Appeal Decision

Appeal Ref: APP/R5510/W/24/3345820

110 Torcross Road, Ruislip Hillingdon HA4 0TG

- The appeal is made under Section 78 of the Town and Country Planning Act 1990 against a refusal to grant planning permission.
- The appeal is made by Mr Andy Collins against the decision of the London Borough of Hillingdon.
- The application reference is 22474/APP/2024/897.
- The development proposed is described as the 'Proposed conversion of garage into 2 storey 1 bedroom single family dwelling.'

PROPOSED SITE PLAN
1:100

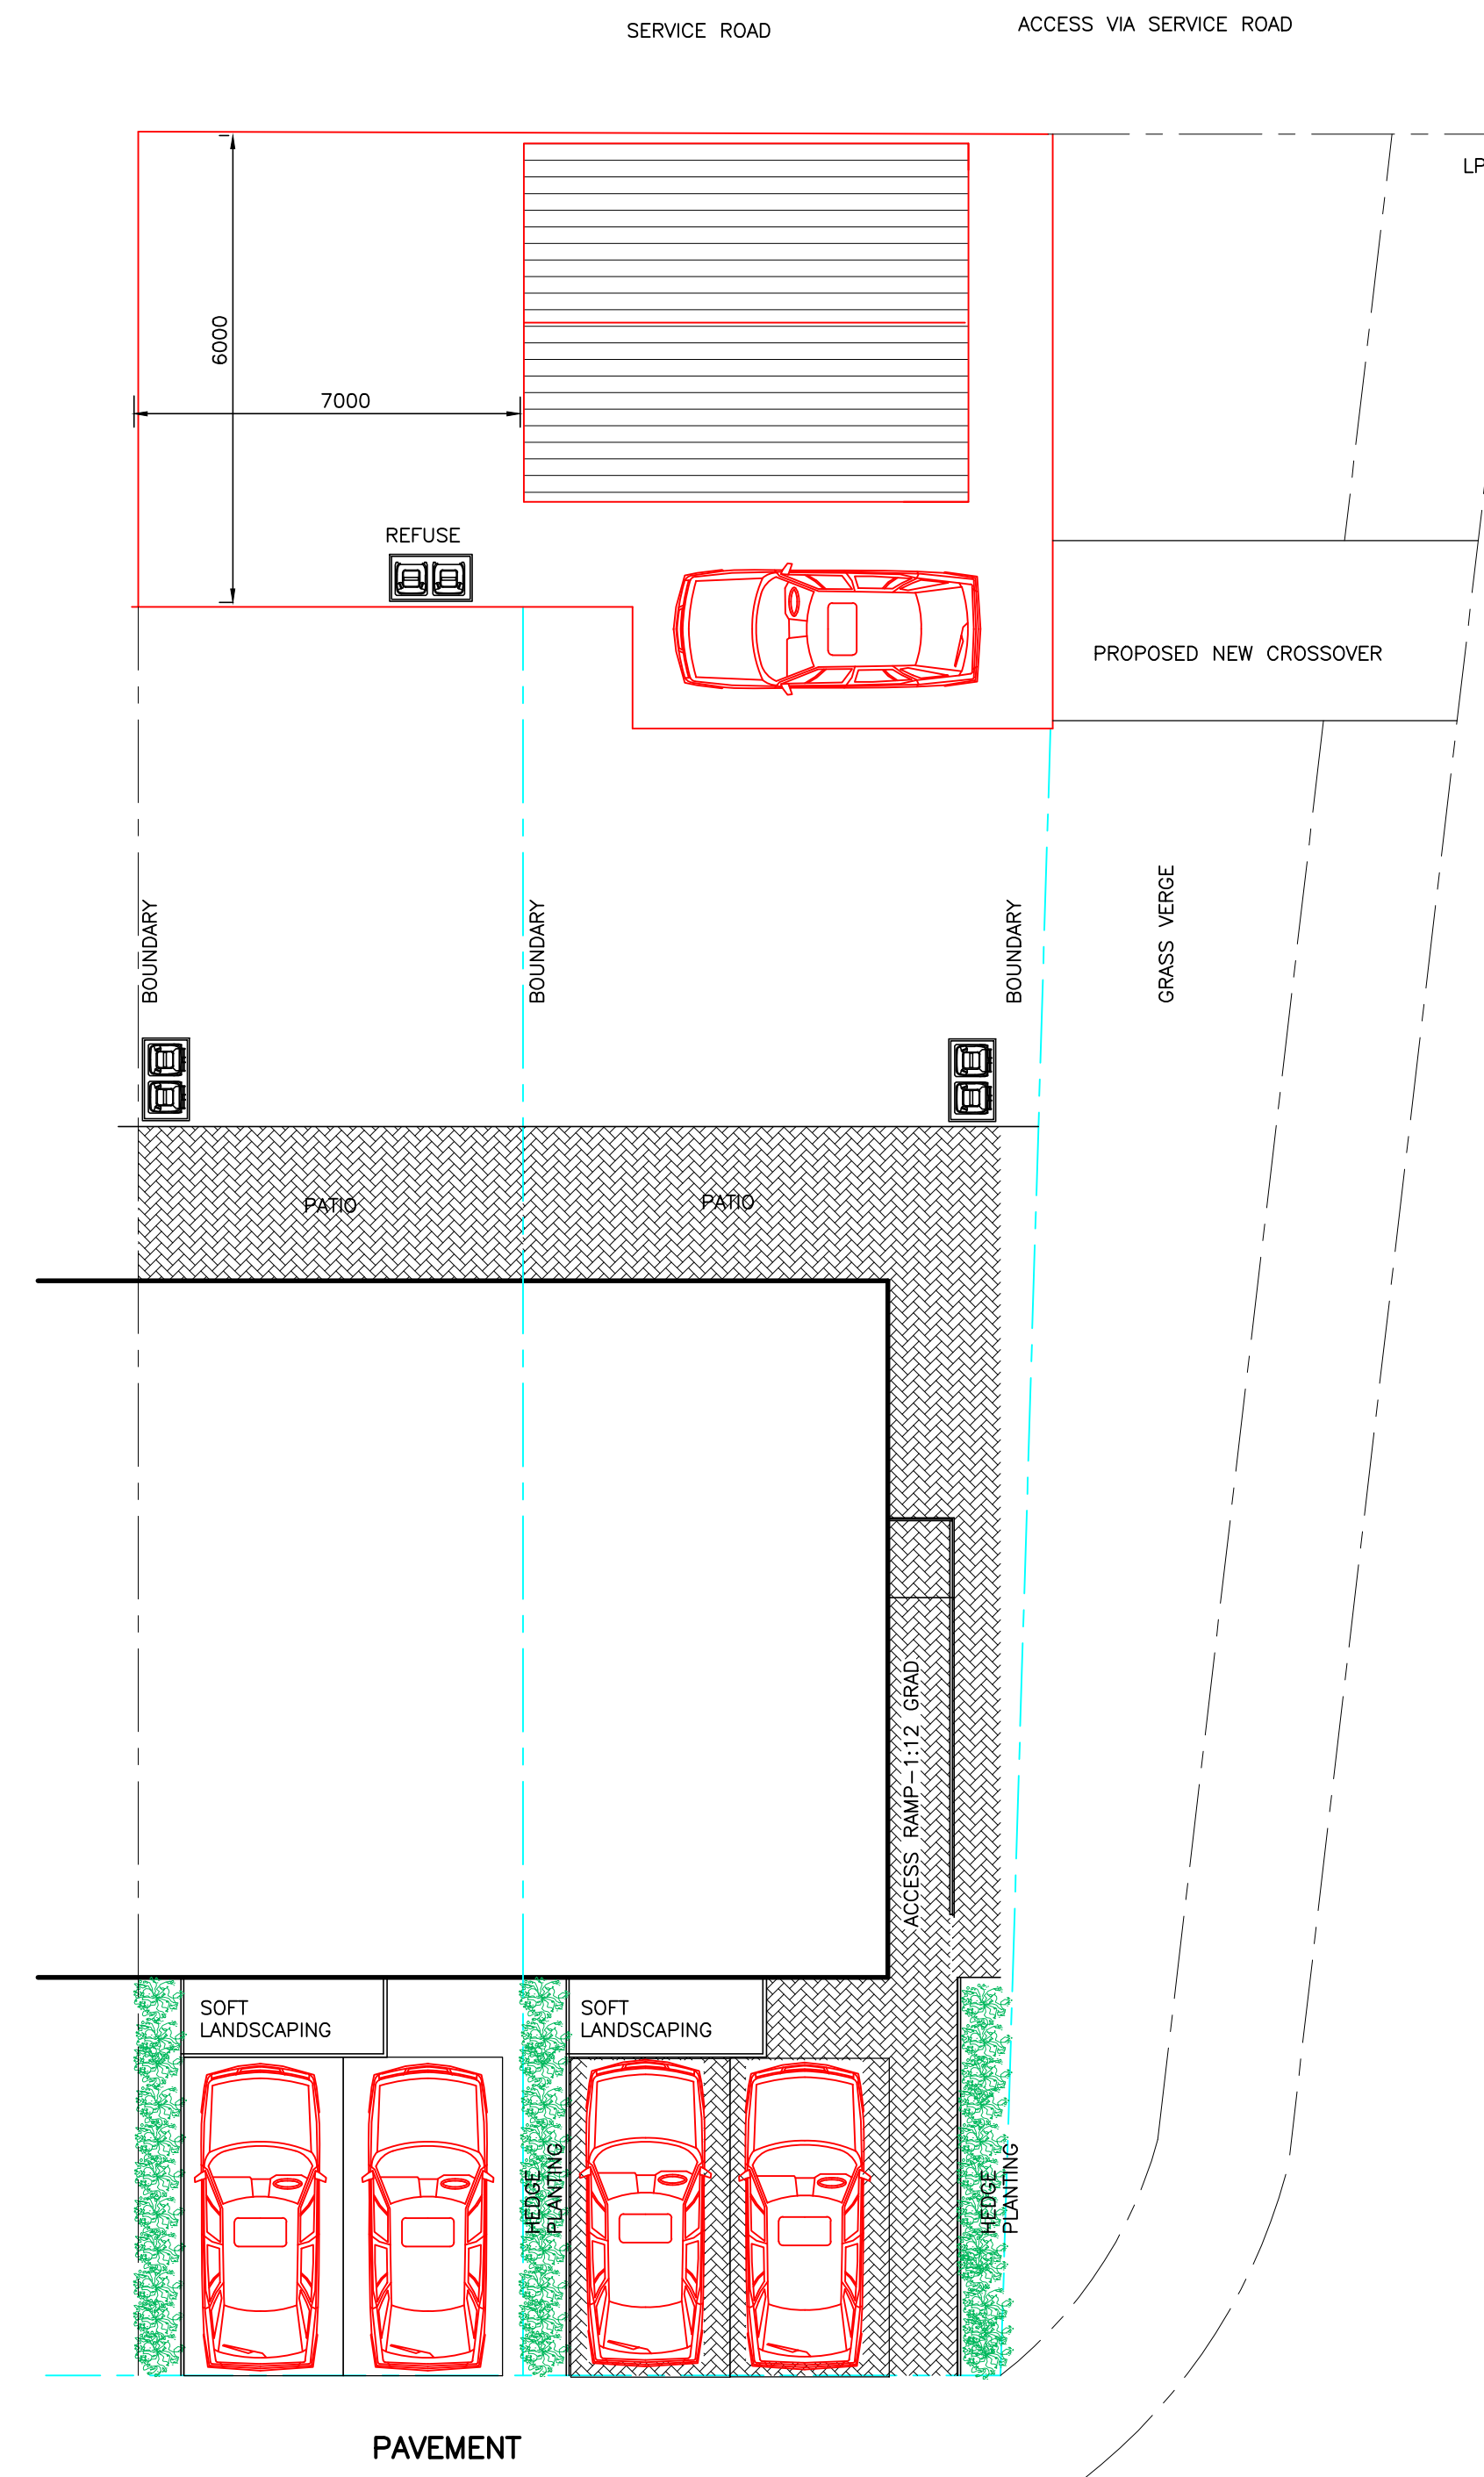
3. I note that on the refused plan⁴ that the 'Proposed Site Plan' shows the roof of the proposed dwelling as being pitched and gabled which does not match the elevation plans or the 1st floor plan (which shows the outline of the hipped roof). Despite this, it is clear to me that the proposal is for a hipped roof and I have made my decision on this basis.
4. The Council's Decision Notice contains five reasons for refusal. As Reason No.s 2 and 3 both deal with living conditions, I have dealt with these together under the matter of living conditions.

PROPOSED SITE PLAN
(1:200)

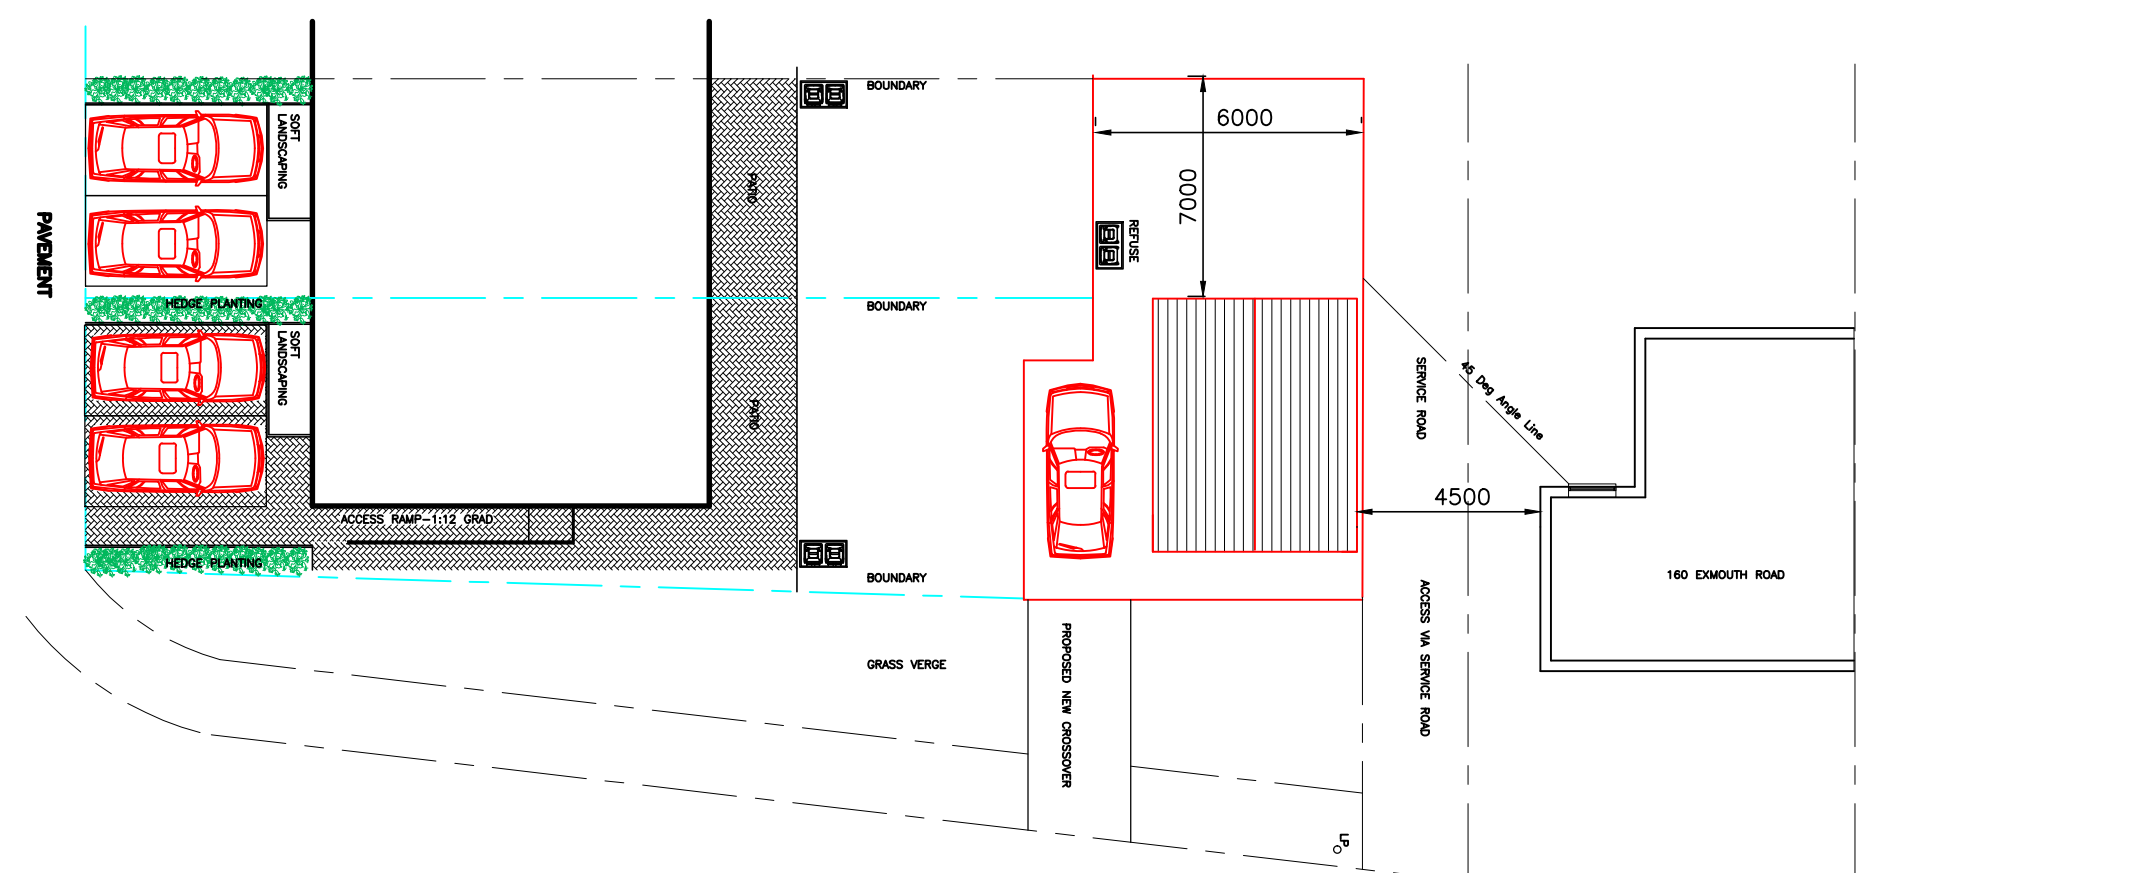
20. It is proposed to undertake operational development to install a vehicular crossover over the grass verge in front of the property. The red line shown on the proposed plan which seeks consent for the development that includes the access does not include the grass verge in front of the property within the red line which from the appeal documents appears to be part of the adopted Highway. I note that the Application Form submitted by the Appellant has Certificate A signed, which would mean that the Appellant is the owner of the site encapsulated by the red line. Given that the crossover is outside the red line it would appear that the incorrect Certificate has been signed as the Appellant would need to serve notice upon the owner of the grass verge and the signing of a different certificate in the Application Form.
